To: Ric Weinschenk From: Mike Nugent
Fax: 766-2999 Date: August 20, 2002
Phone: 766-2900 Pages: 1
Re: 548 Island Ave. (092 A001) CC:

A preliminary review of the above project revealed the following deficiencies :

SITE PLAN

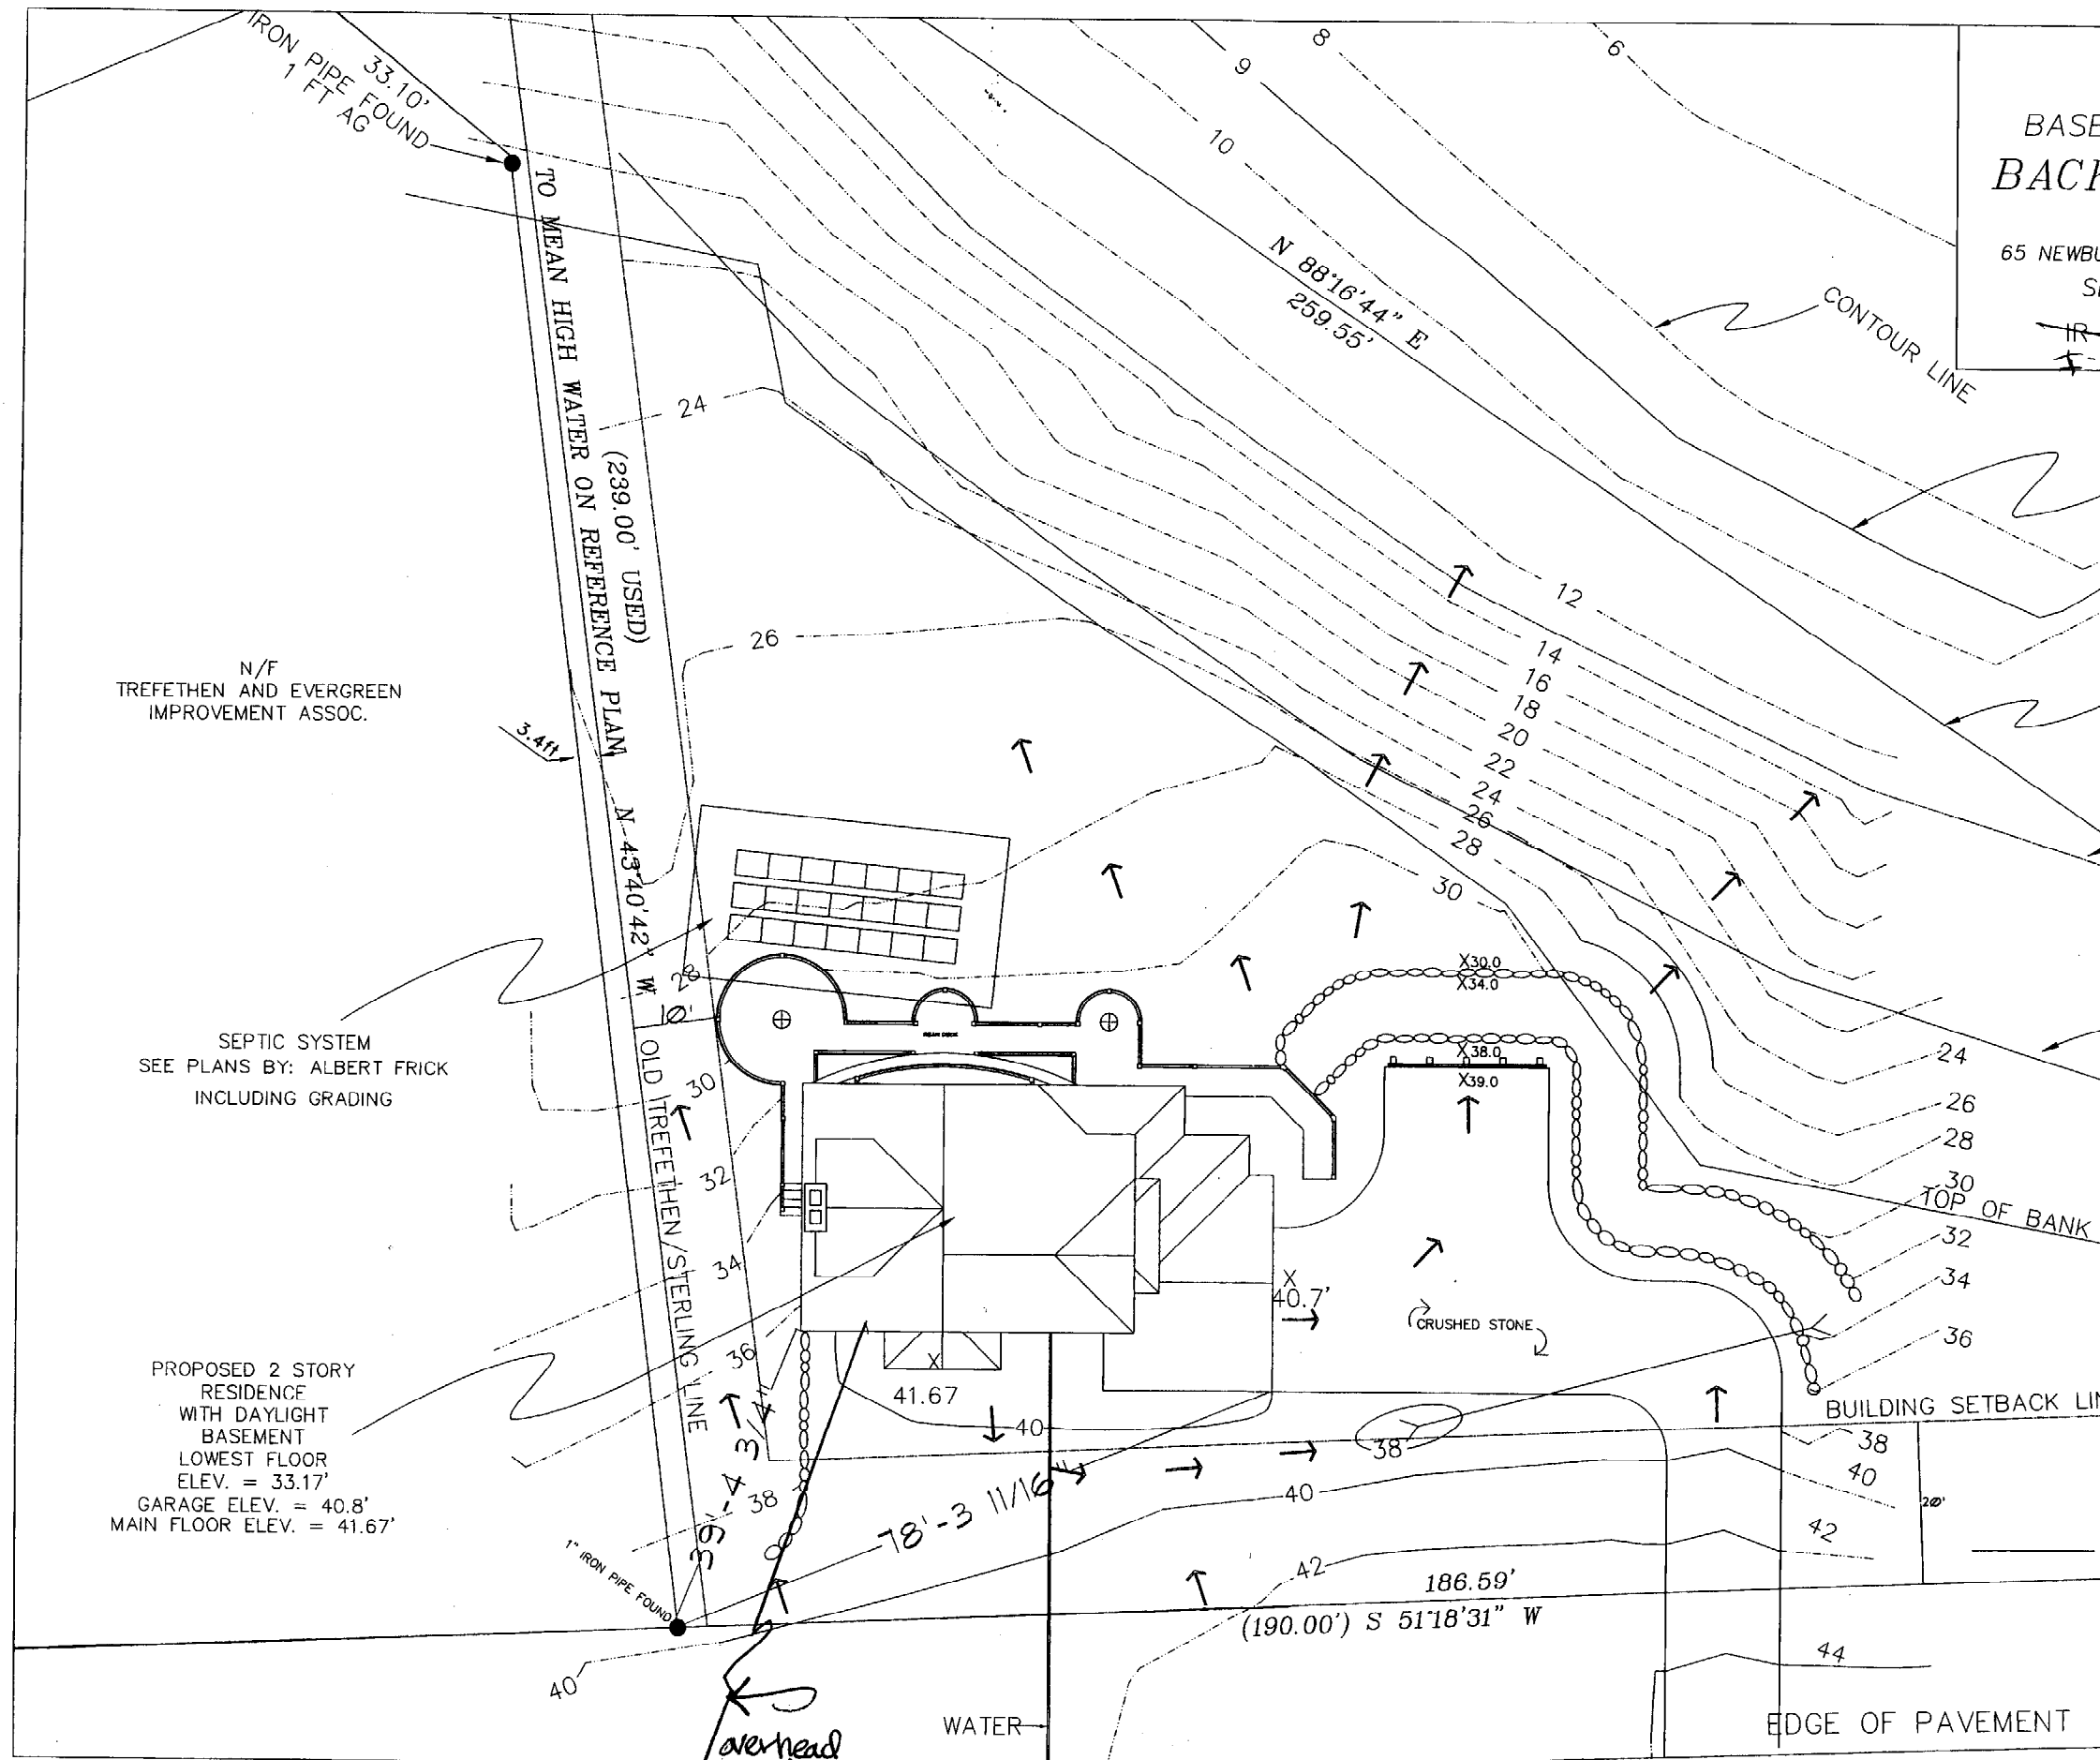
- 1) The HHE 200 form provided by Albert Frick is unacceptable, as the variances sought have been denied. Also it appears on the site plan that the structure is too close to the leach field.
- 2) The plans lack adequate structural details to establish Code compliance. Attached is a copy of the checklist used for review.
- 3) Prior to the issuance of the demo permit , an inspection must occur with a CEO, Jay Reynolds and representative from your surveying company to establish existing grade for the purpose of documenting Building Height, which will be verified by you surveyor when the roof framing is in place.
